PLANNING CONSULTATION RESPONSE

Application No	2026/0341
Proposal	Change of use from Doctors Surgery (Use Class E(e)) to Respite Unit Residential Institution (Use Class C2)
Address	Galtee More Residential Home, 164 Doncaster Road, Barnsley, S70 1UD
Date of Consultation Reply	22/07/2026
Consultee	Katie Lawrence, Planning Ecologist

TITLE
PROPOSED BLOCK &
SITE PLAN

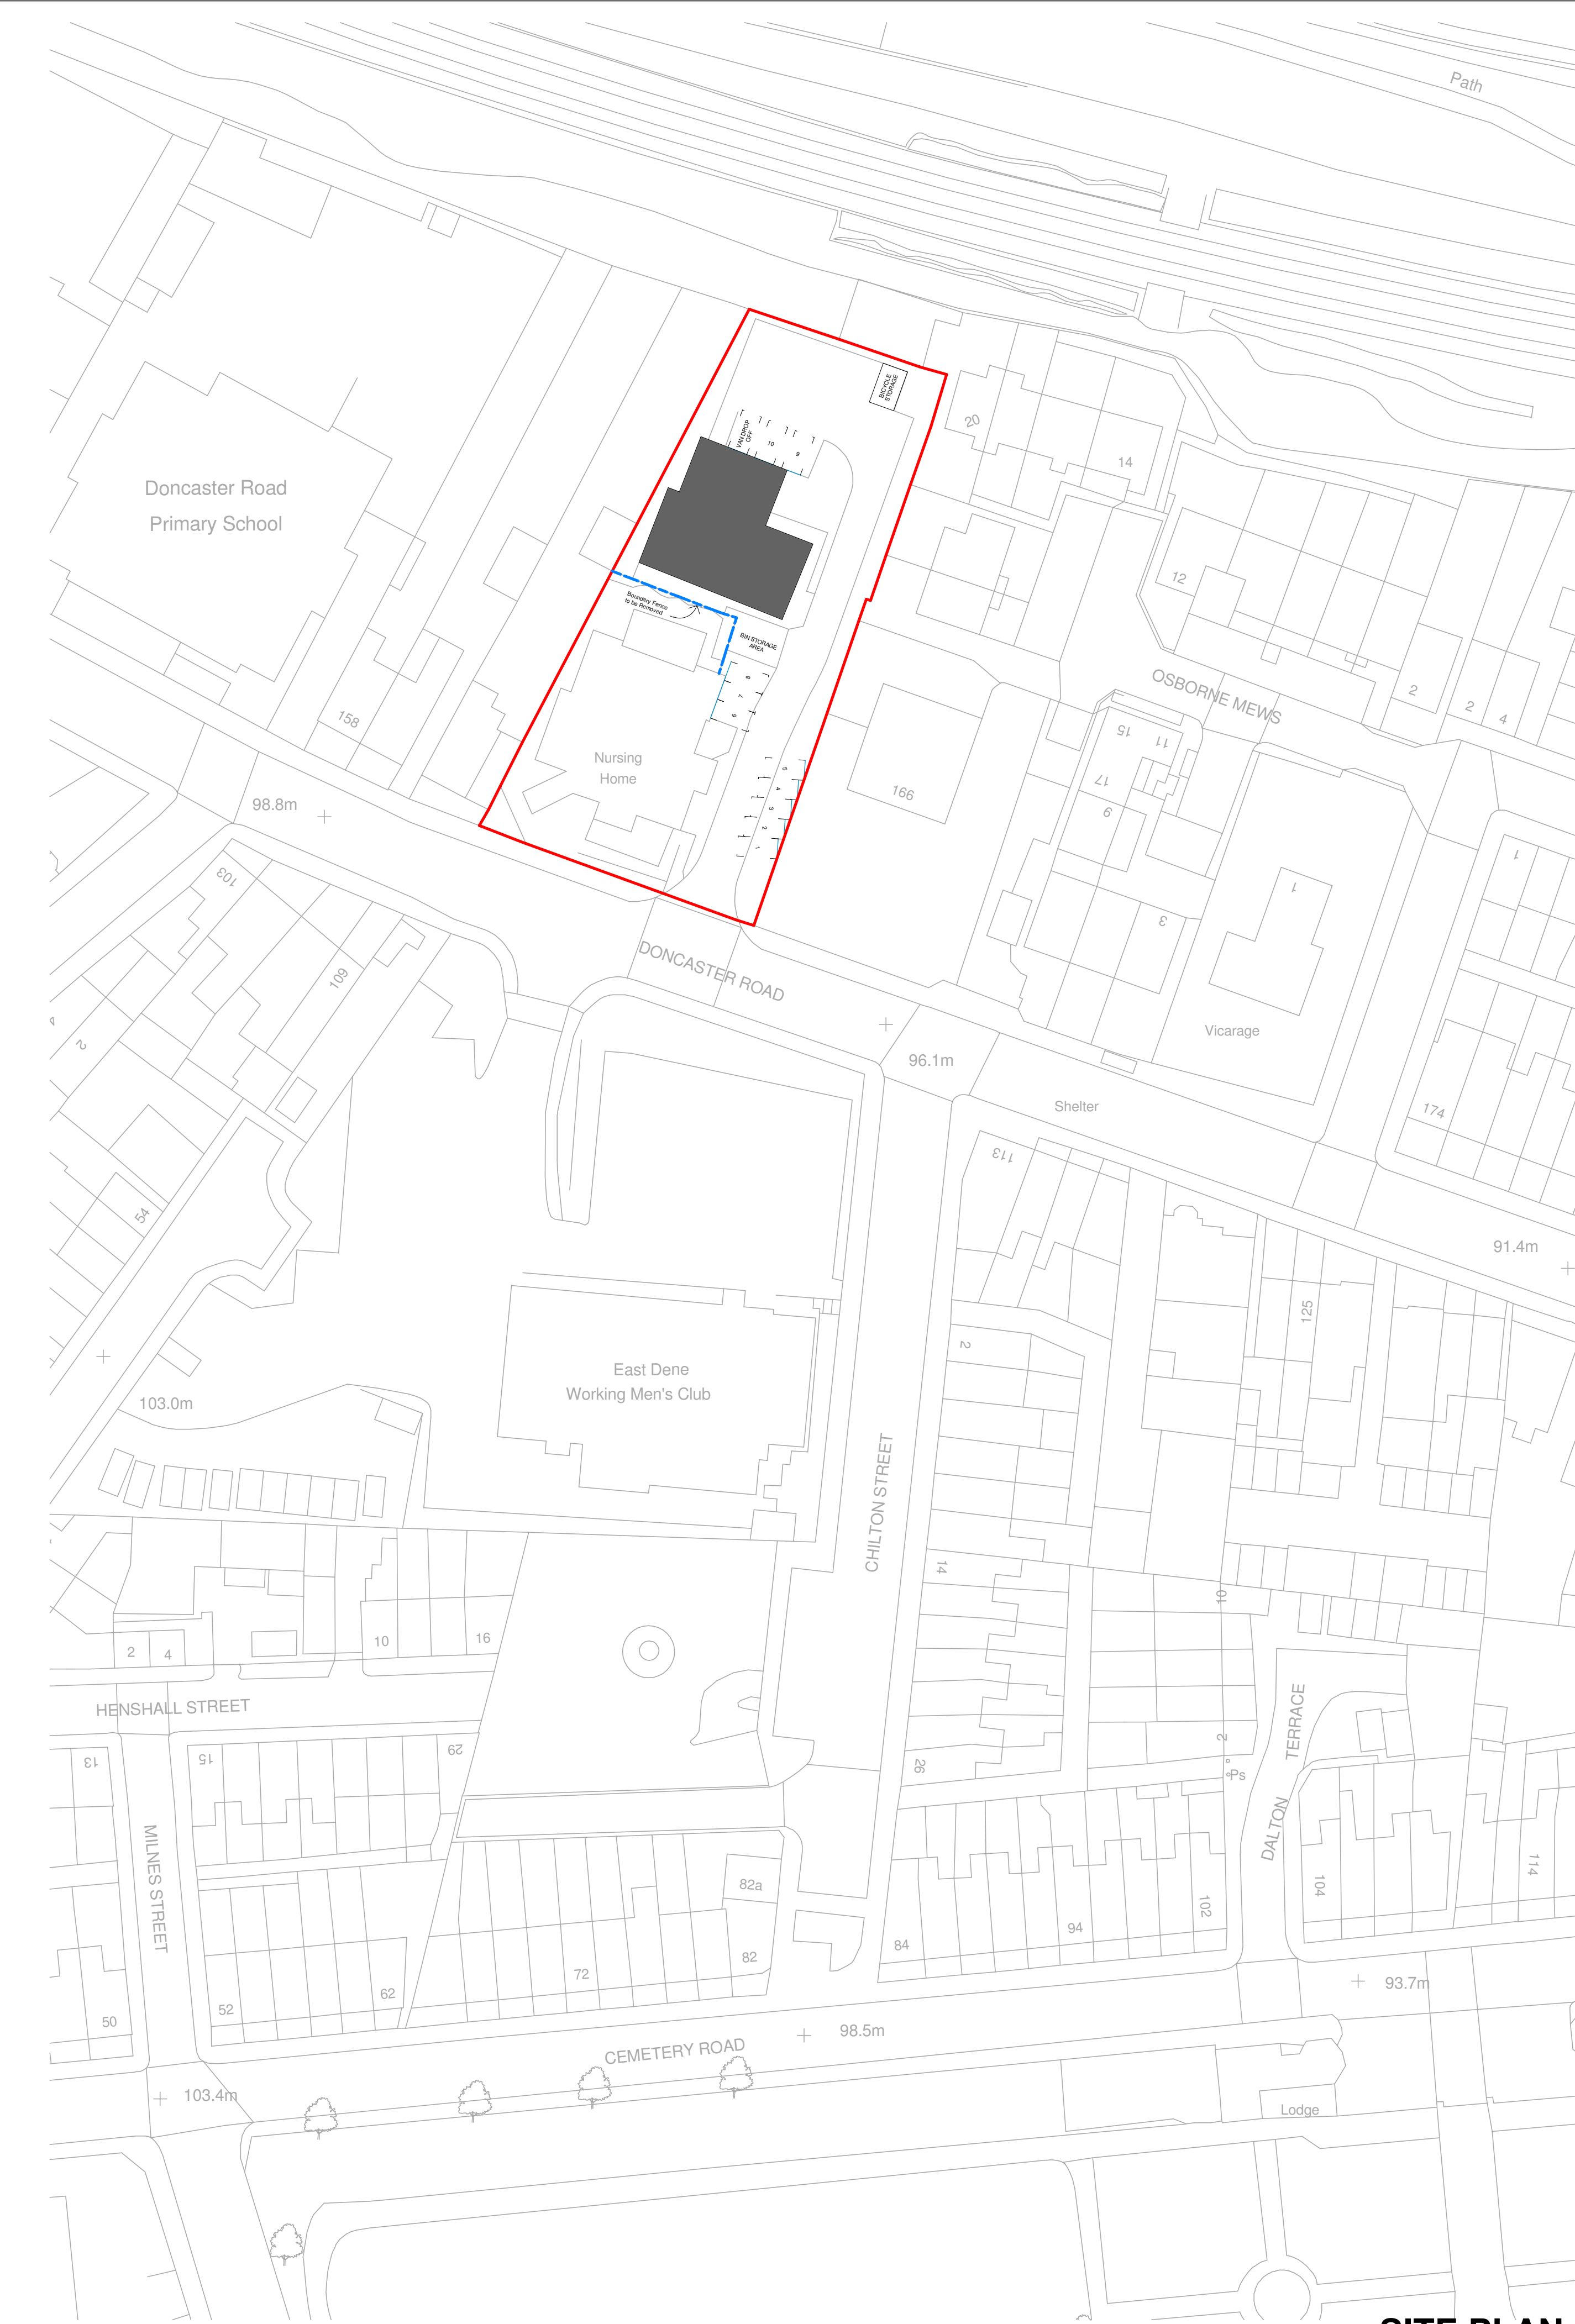
- The application form submitted indicates that the proposals are exempt from Biodiversity Net Gain (BNG) under the de minimis rule, with less than 25m² of habitat being impacted by the proposals. When referring to the proposed block and site plan it shows a boundary fence as being removed. Can the applicant confirm if the vegetation associated with the boundary fence will be affected? Aerial photographs show a hedgerow/line of trees associated with the fenceline. The de minimis rule states that BNG does not apply to developments that impact less than 25m² of on-site habitat or 5m of on-site linear habitats such as hedgerow. As the hedgerow/line of trees is over 5m in length, if this is to be affected the development is likely to be subject to the Biodiversity Gain condition and relevant information will need to be submitted as part of the application. Reference can be given to the biodiversity appendix of the local validation list for required information, if necessary (<https://www.barnsley.gov.uk/media/yyhmuadm/biodiversity-appendix.pdf>).

- If the hedgerow/line of trees is to be affected by the proposals, this could result in potential impacts on nesting birds. Again, can the applicant confirm if this vegetation is to be affected so appropriate measures can be secured?
